Our Ref: DOC19/132679-23  
Your Ref: SSD 9255

**Re: New England Solar Farm – SSD 9255 – EIS Exhibition**

## Attachment 1: Detailed OEH Comments – New England Solar Farm SSD 9255

Plant community type and vegetation zone mapping within the development site, and plot locations

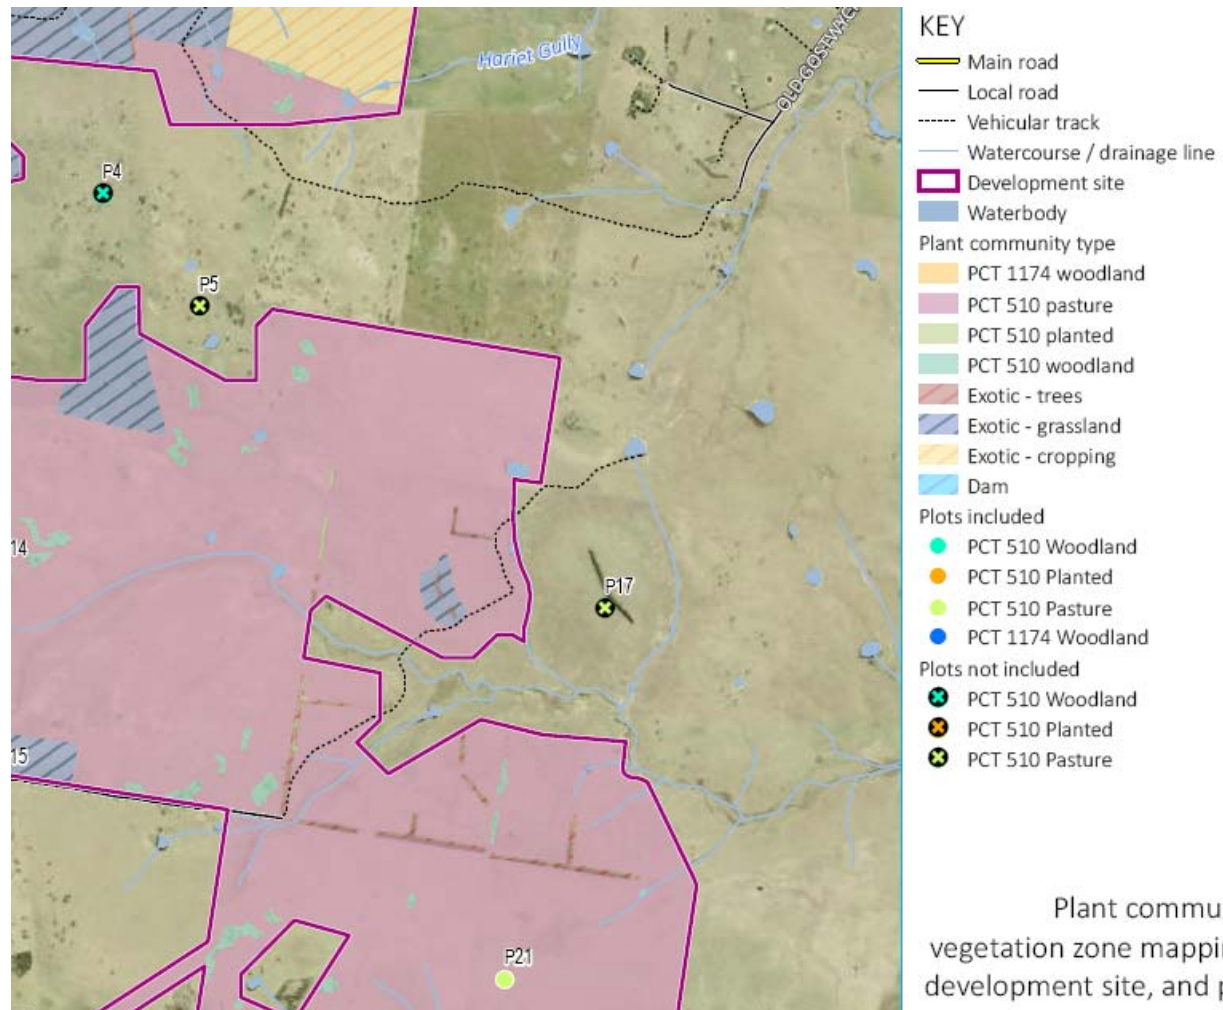
The BDAR assessment of ecosystem credit species should not have included areas of planted native vegetation (i.e. vegetation zone 3) for the reason specified above. Furthermore, to accord with Section 3.1.1.3(f) of the BAM, the assessment of ecosystem credit species should not have considered vegetation zones with a vegetation integrity score less than 15 (e.g. vegetation zones 1 and 2).

The BDAR assessment of ecosystem credit species excluded swift parrot (*Lathamus discolor*) from vegetation zone 4 (i.e. PCT 1174) on the premise that preferred feed tree species were absent. However, PCT 1174 contained silvertop stringybark (*Eucalyptus laevopinea*), which is a winter-flowering species likely to provide a suitable foraging resource for the swift parrot. Furthermore, swift parrots may forage on lerp-infested yellow box (*Eucalyptus melliodora*) in PCT 1174.

3. Revise the BDAR assessment of ecosystem credit species to exclude consideration of areas of planted native vegetation and vegetation zones with a vegetation integrity score less than 15.

4. Revise the BDAR assessment of ecosystem credit species to include swift parrot (*Lathamus discolor*) as a candidate ecosystem credit species for vegetation zone 4 (i.e. PCT 1174).
